**Written Representation on behalf of Conoco Phillips
Limited**

**Proposed Able Marine Energy Park
South Bank of The River Humber
Immingham
North Lincolnshire**

Planning Inspectorate Reference : TR030001

Title: Indicative Landscape Masterplan

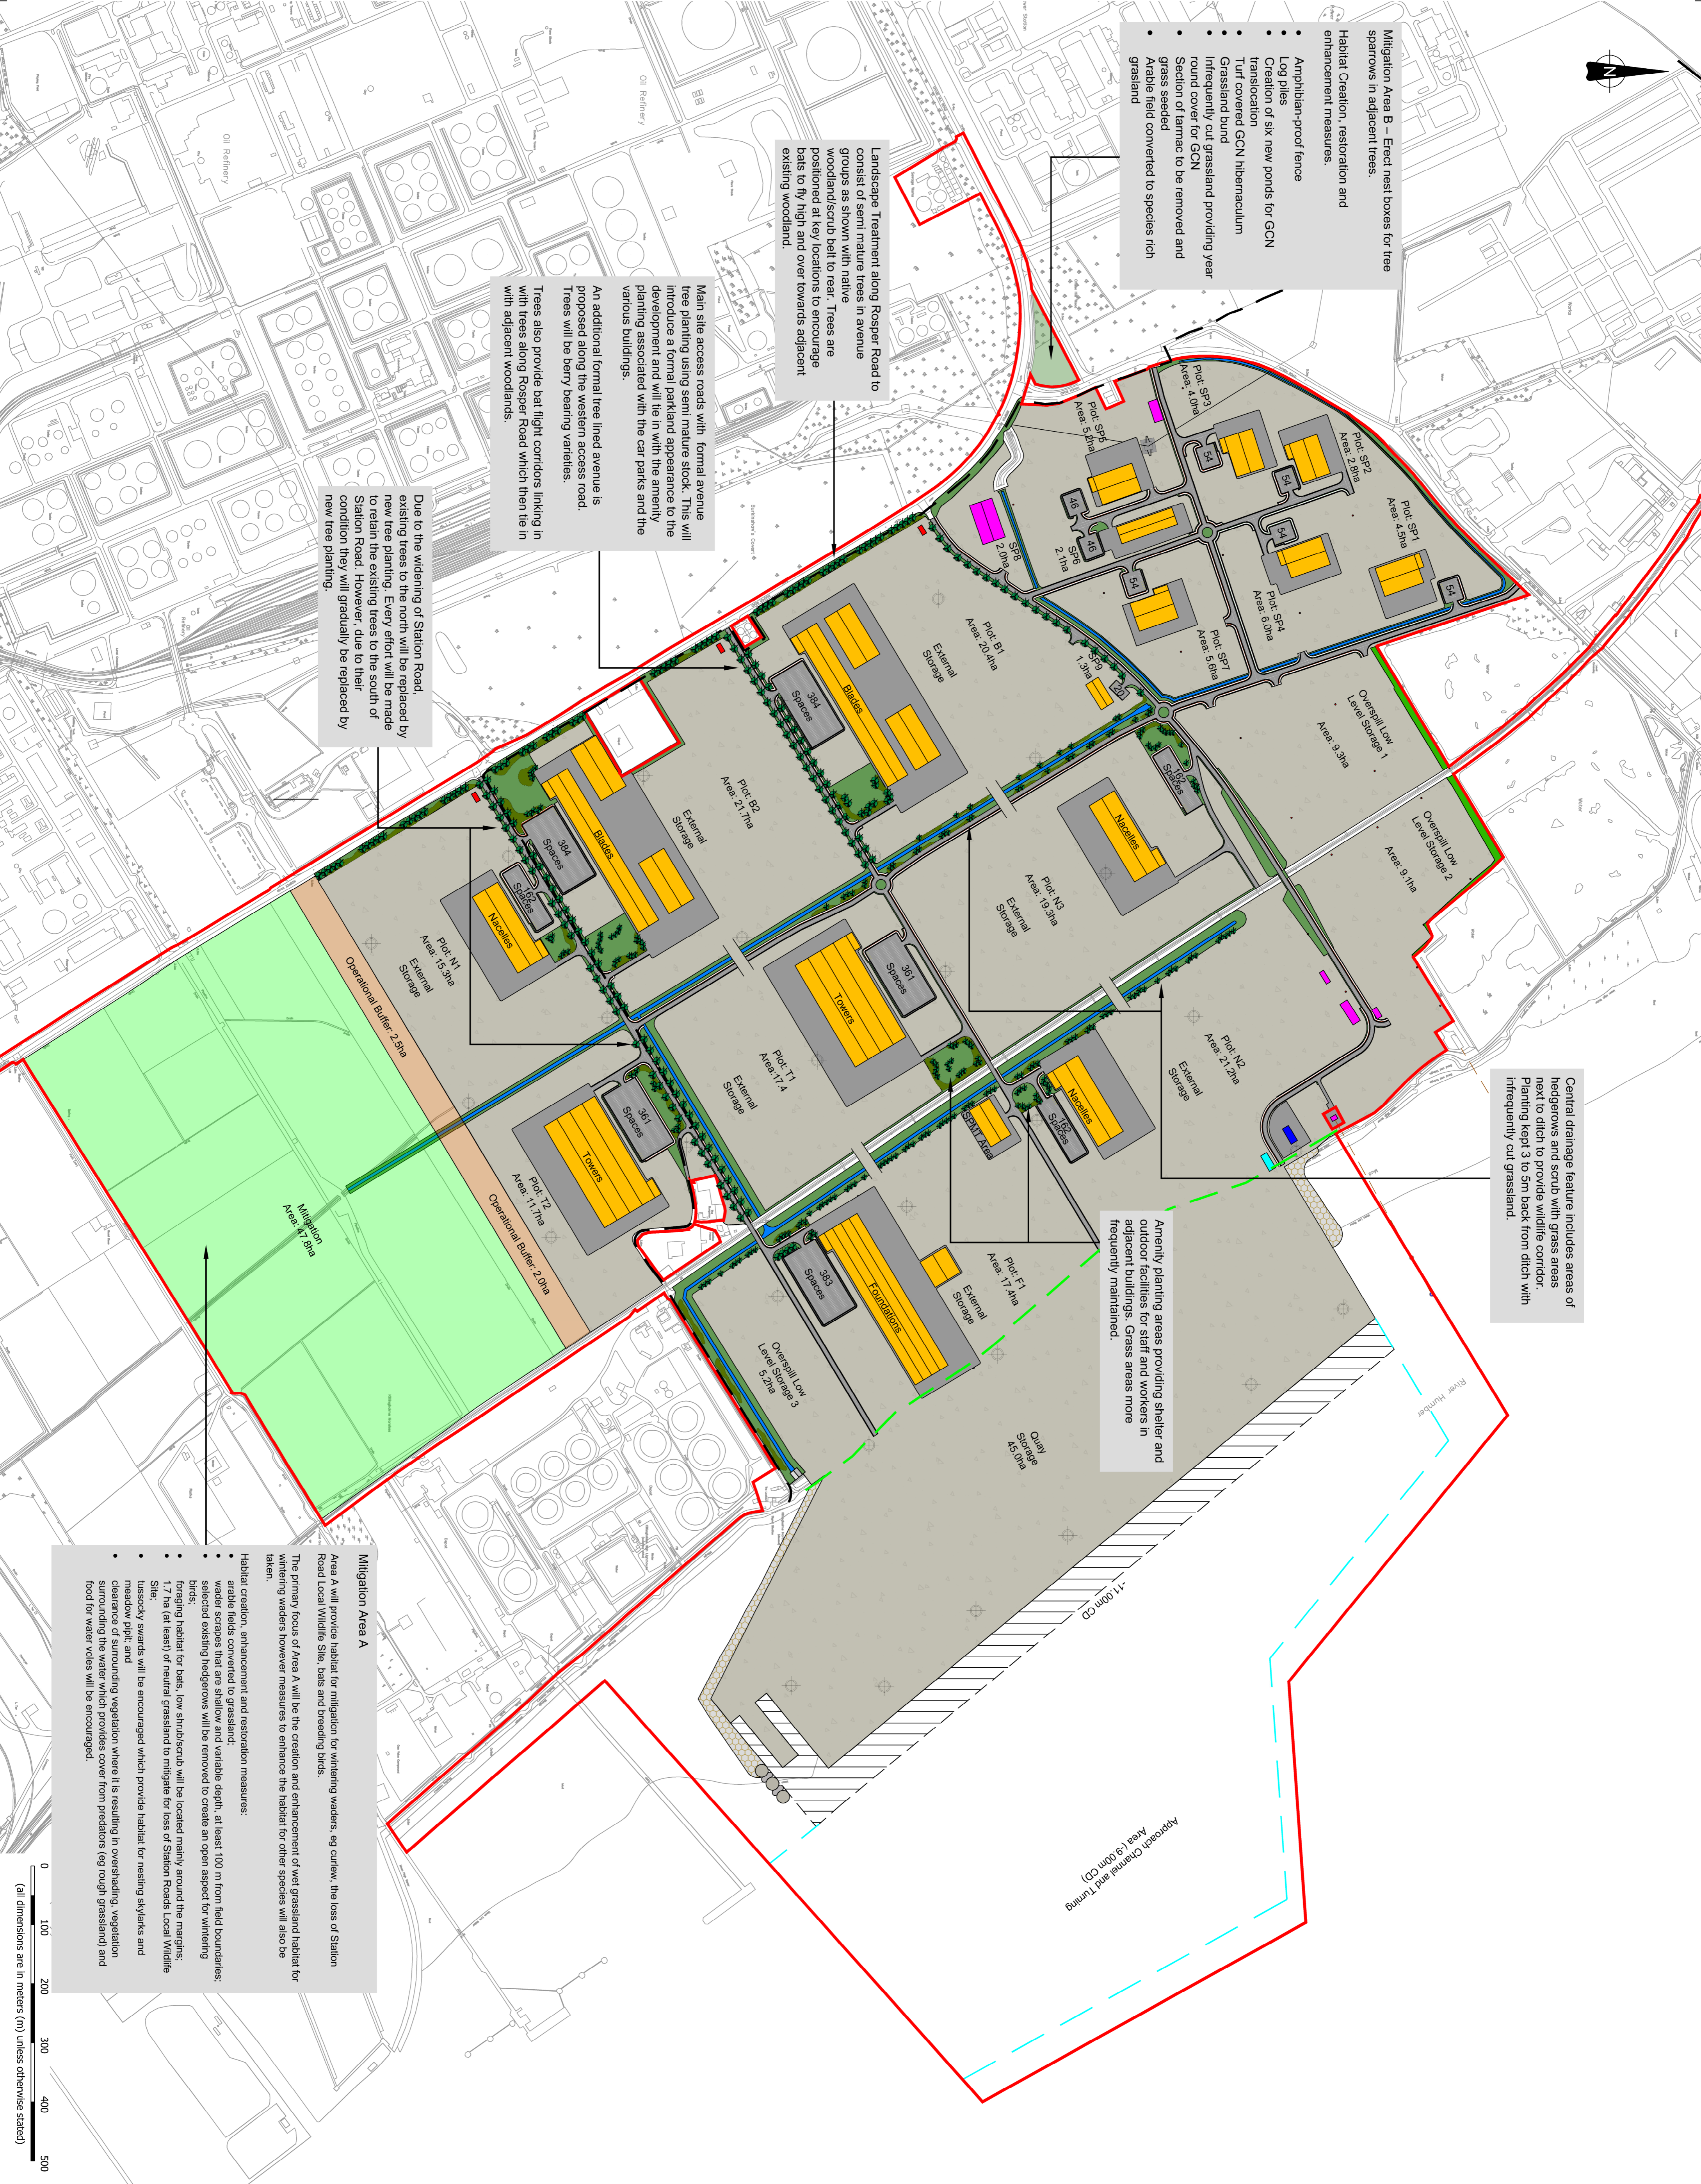
- 2.1 CPL note that 'Mitigation Area A' (the "Mitigation Area") shown on the Indicative Landscape Master Plan lies between the proposed AMEP and land owned by CPL.

- 2.10 CPL would like to ascertain further information as to why this parcel of land has been identified as a 'mitigation area', when its allocation in the Local Plan is for industrial purposes?

- 2.12 There are already two areas that lie outside of the 'site' identified in the Local Plan as Sites of Importance for Nature Conservation, and there is concern that creating a further such area may fetter or severely restrict the ability of CPL to carry out any development operations upon the Rosper Road Site. As part of the decision making process, it is argued that the land use allocation represents the preferred land use. Have Able considered that a potential option would be a commuted sum covered as part of a Section 106 Agreement to reinforce existing or provide additional wetland/wildlife/ecological habitats in more suitable locations?

- 2.13 In terms of the statement referred to in paragraph 2.9 above, CPL consider it difficult to determine that if this land were to become a mitigation area and developed as described in paragraph 4.5.1 of the Habitat Regulations

Assessment Report how it would be managed and by whom it would be managed? In addition it is argued whether or not this area could be used as such when CPL have four operational overground pipelines (the “Pipelines”) the subject of an existing Deed of Grant that dissect this site and run east to west across it? Has there been any consideration of the need for continual access and maintenance at short notice for the Pipelines, and the potential harmful impact upon the mitigation area should access to repair or maintain the Pipelines be required?

- 2.14 CPL does not therefore consider the Mitigation Area to be appropriate given these factors and also given the status of the Local Plan. The Local Plan has gone through various rounds of public consultation, its Examination in Public prior to being formally adopted. This is a full democratic process which holds significant weight unless there are material considerations that would dictate otherwise. In view of this CPL consider that the use of the land for industrial purposes should be the preferred option here.

- 2.15 CPL would also raise the matter of the operational buffer, its purpose and what it is to comprise of? In addition, it is asked whether or not there has been any consideration of the need to provide a form of buffer, landscaped area or maintenance strip to the southern and western boundaries of the site where the Pipelines cross Rosper Road?

- 2.16 On the basis of the above CPL would suggest as a minimum the inclusion of an additional "Operational Buffer" to the south of the Mitigation Area as there is proposed to the north. This further buffer area would run alongside Marsh Lane which is the main access road to its land holding comprising an LPG Underground Storage Site (“the Caverns”). This buffer would prevent the migration of adjacent habitat onto the allocated industrial land, and therefore assist in the future development of the Rosper Road Site.
